**Consultation Response from KC,
Conservation & Design**

2026/91306 Lumb Lane Nurseries, Lumb Lane, Almondbury, Huddersfield, HD4 6SZ

Discharge of details reserved by conditions 3 (materials), 4 (windows and doors details), 6 (boundary treatment scheme), 7 (landscaping) and 13 (lighting scheme) on previous permission 2025/92440 for erection of four dwellings

Date Responded: 20 July 2026

Window Details

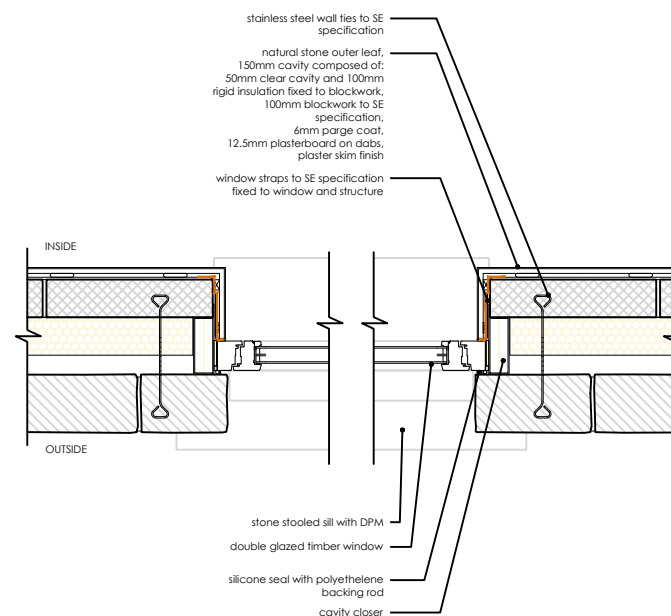
The applicant has provided details of the proposed windows to be timber flush casement double glazed windows with windows recessed 150mm into openings.

The necessary information has therefore been provided and the details are found to be satisfactory. The conservation and design team have no objection to the discharge of condition 4.
